# **Dogger Bank South Offshore Wind Farms**

**Environmental Statement**

**Appendix 10-1 Fish and Shellfish Ecology Consultation  
Responses**

**June 2024**

© ERM, 2024. Contains Ordnance Survey and ICES data. © Crown copyright and database rights 2021

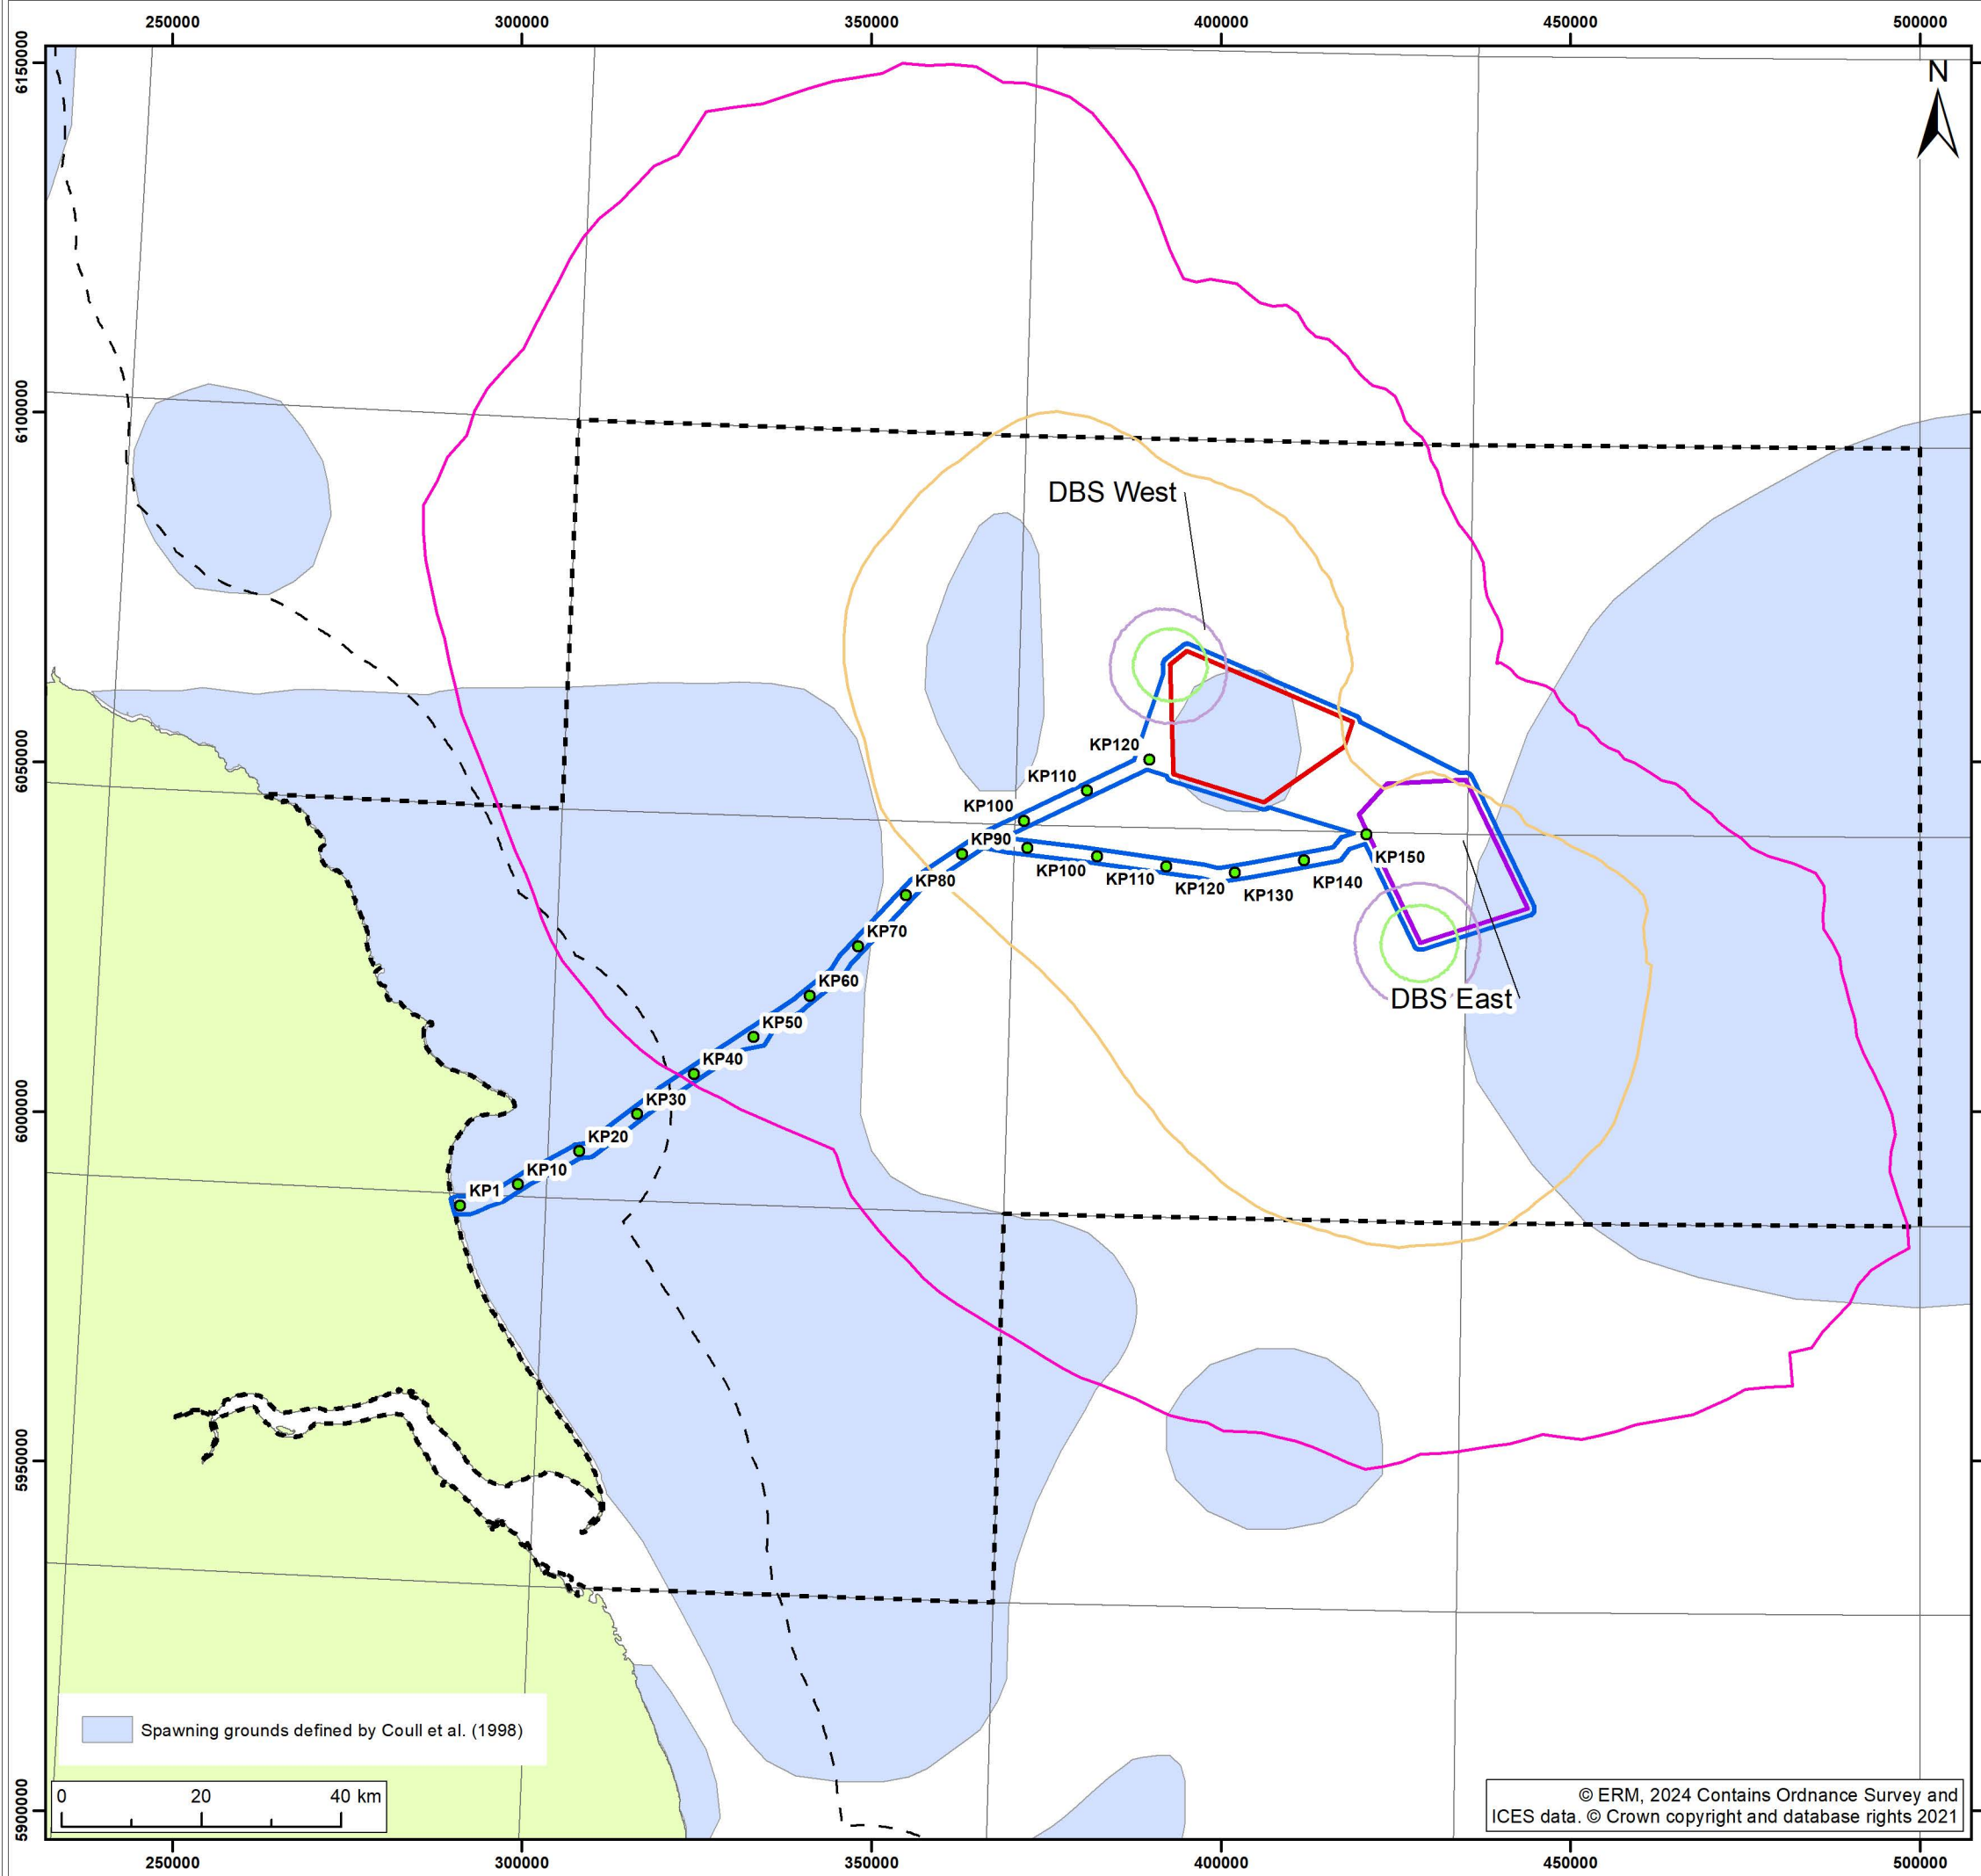
Comment	Project Response
commercially important fishes. The JNCC 1995a and 1995b citations were not included in the reference list for review and comment.	
The MMO notes that herring spawning grounds have not been depicted in Figure 2-11, only their nursery grounds have been mapped. Nonetheless, section 263 acknowledges that Atlantic herring have spawning grounds within the Projects' study area and that the species is highly sensitive to changes in their substrate composition. The MMO note that potential herring spawning habitat has been mapped further on in Figure 2-14, following the method described by MarineSpace (2013a) which the MMO support.	Spawning and nursery grounds of Atlantic herring as determined within Coull <i>et al.</i> (1998), and Ellis <i>et al.</i> (2012) are depicted within <b>Volume 7, Figure 10-6 (application ref: 7.10.1)</b> . Potential Atlantic herring spawning grounds are depicted in <b>Volume 7, Figure 10-7 (application ref: 7.10.1)</b> , following the methodology described within Reach <i>et al.</i> (2013).

| Figure:10-6b                                             | Drawing No: PB2340-MAR-OF-ZZ-DR-Z-0017 |                                                             |                     |

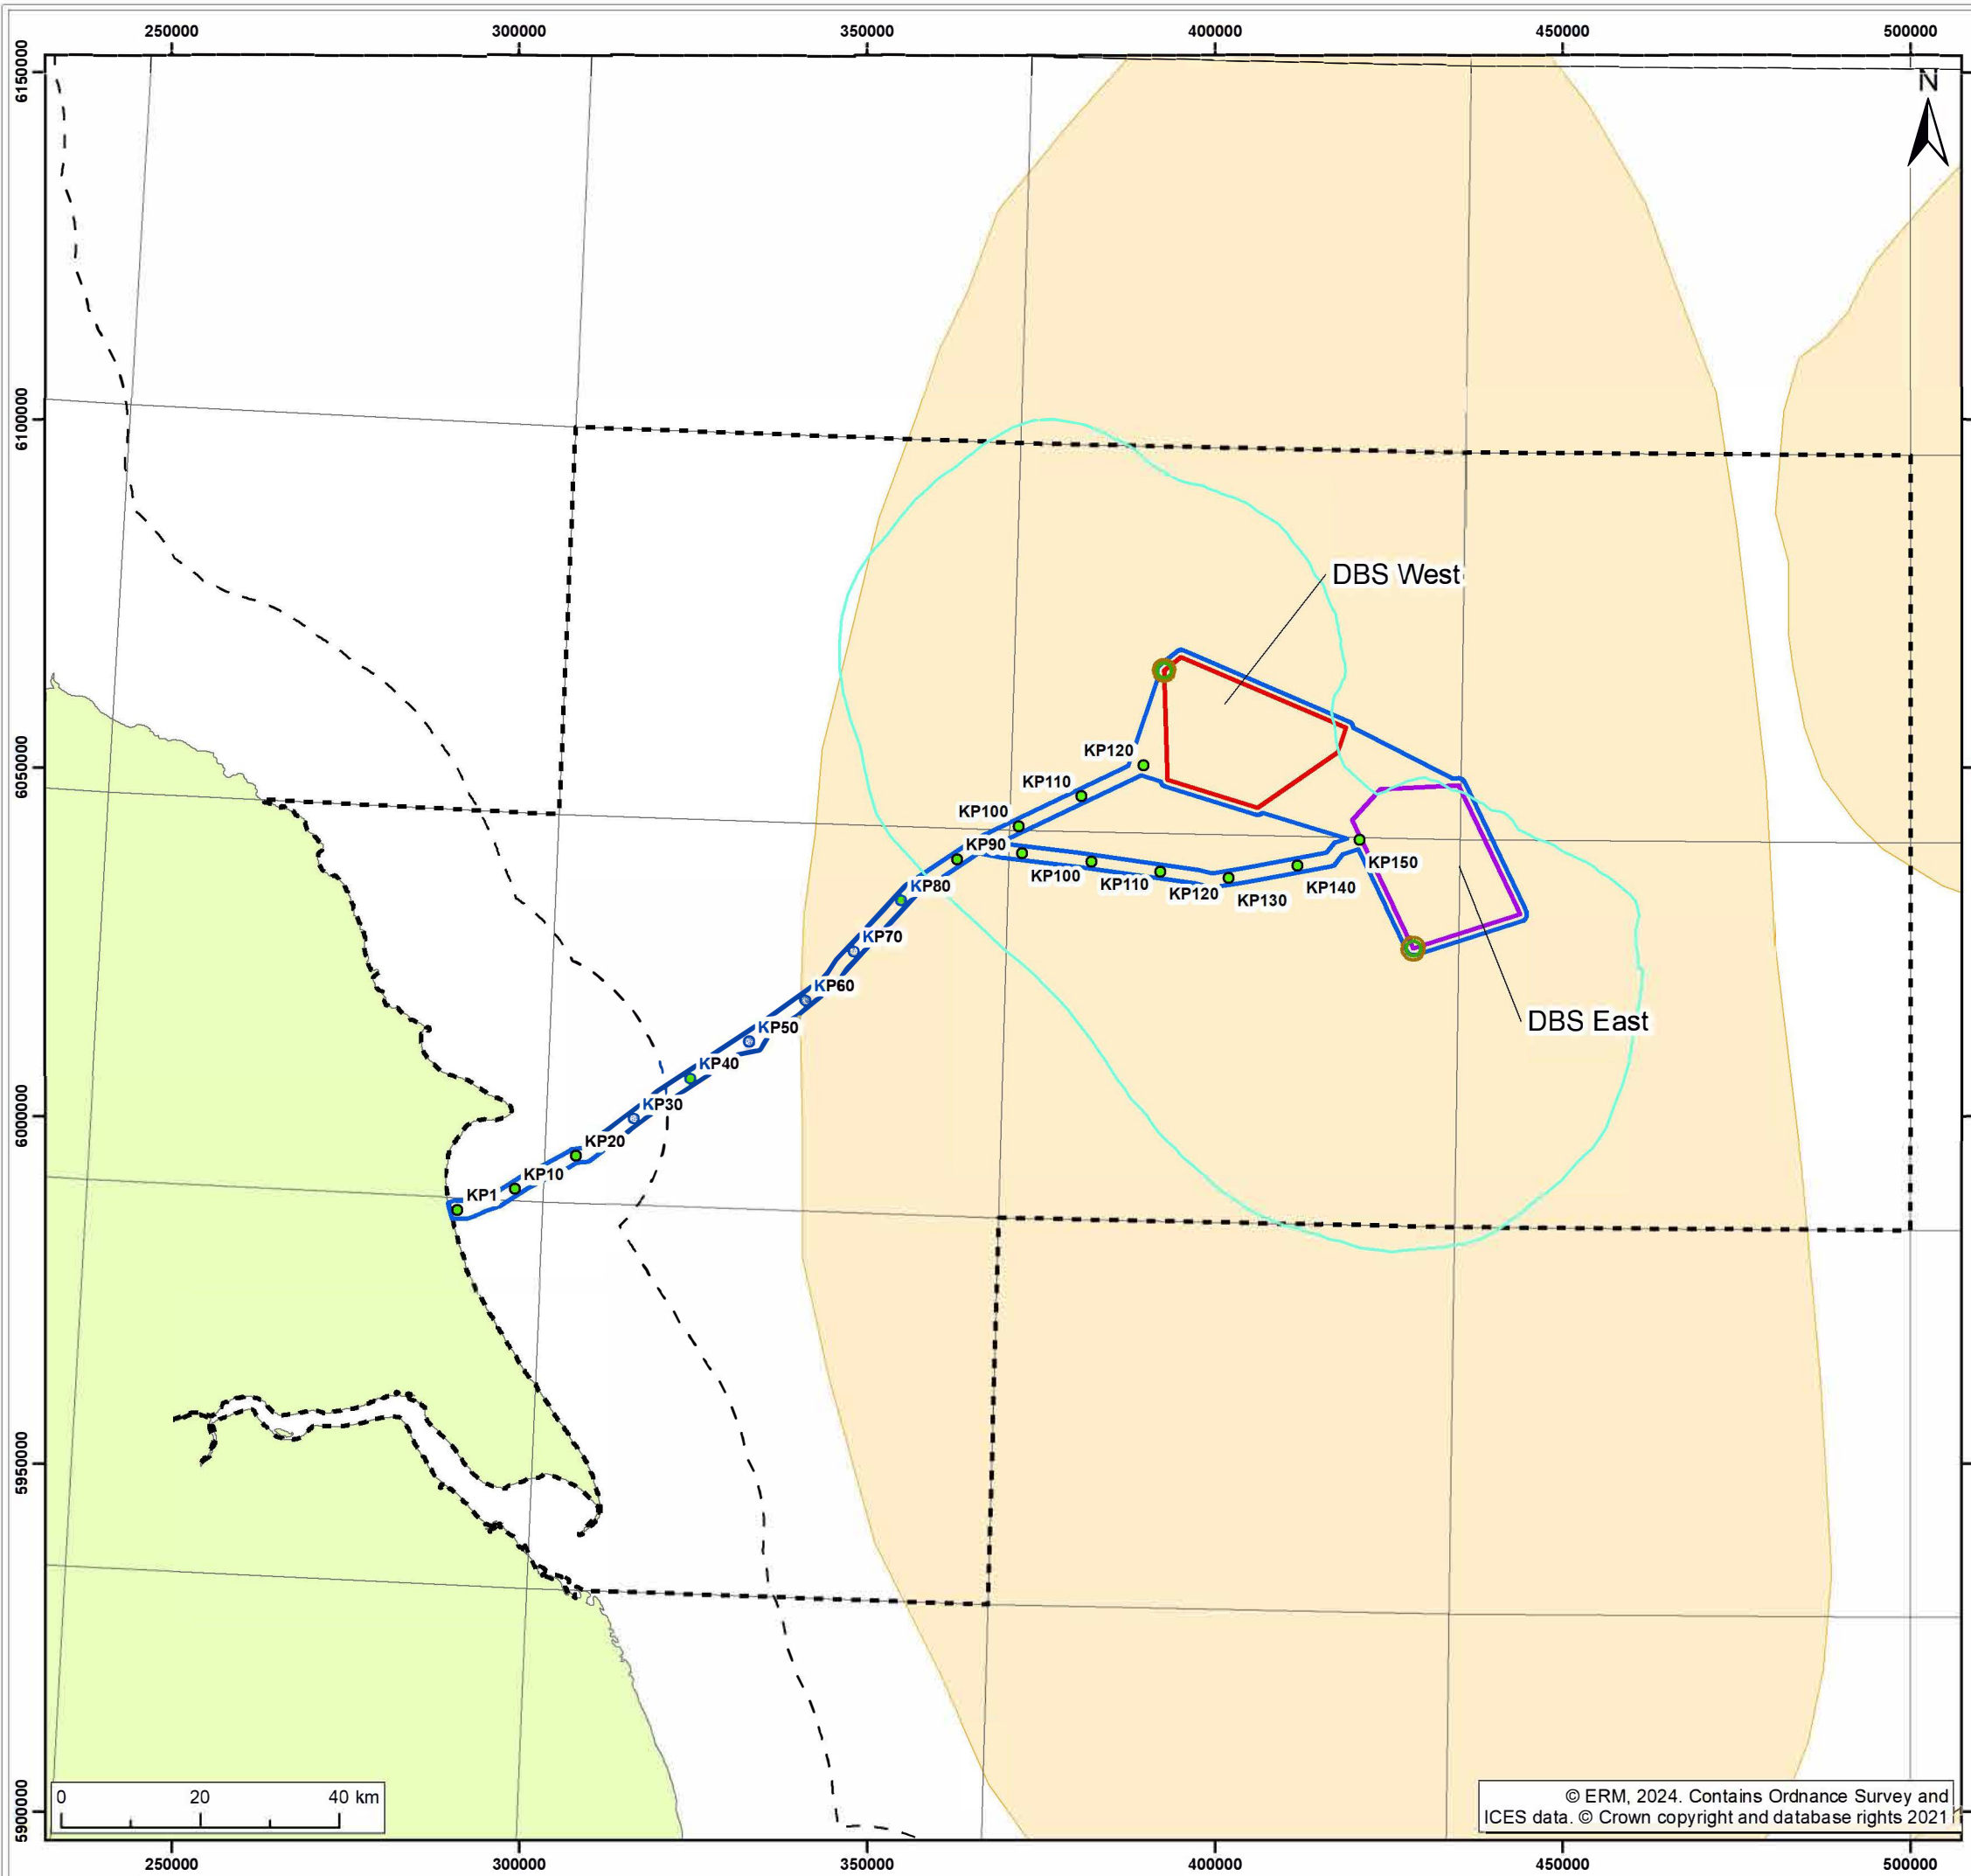
<p>According to the PEIR documents, roughly the entire DBS West array (estimated at 95.3% in Table 10-15) rests within areas that The Applicant has identified as high spawning potential for sandeel (Figure 10-5). Worst-case scenario estimates (Table 11-2) place the direct habitat loss within the DBS West array around 3,813,562m<sup>2</sup>, which would equate to a loss of roughly 3,634,324m<sup>2</sup> of high-spawning-potential habitat. In Volume 7, Chapter 10 Fish and Shellfish Ecology, section 104 of Chapter 10, The Applicant claims that ‘these are a species of national importance that are anticipated to recover to baseline levels within 1 – 7 years’. Unfortunately, this claim was not referenced in the PEIR documents. Upon examining the literature, LWT found reference to a similar timeframe in van Deurs et al. (2012) (i.e., 1–7 years). However, the context of that study and these Projects are completely different. Van Deurs et al. (2012) states that the study area was ‘a sink rather than a source for <i>A. marinus</i>’. In contrast, these Projects are expected to negatively impact an important source—as outlined by the 95.3% overlap of DBS West and estimated loss of roughly 3,634,324m<sup>2</sup> of habitat considered to have high spawning potential—for <i>A. marinus</i> recruitment. We could not find reference for the short- and long-term impacts of offshore development on sandeel spawning and/or nursery habitat (i.e., source habitat). Therefore, the assumption and claim of recovery within 1–7 years following these Projects (Volume 7, Chapter 10 Fish and Shellfish Ecology, section 104) is misleading and unsubstantiated.</p>	<p>The assessment of Temporary Habitat Disturbance (<b>Volume 7, Chapter 10 Fish and Shellfish Ecology (application ref: 7.10)</b>, section 10.6.1.1.) has been revised to include a recovery period for the benthic fish receptor group, which includes sandeel, of 2-10 years as described within the Joint Nature Conservation Committee (2022) Supplementary Advice on Conservation Objectives for Dogger Bank Special Area of Conservation referenced.</p>
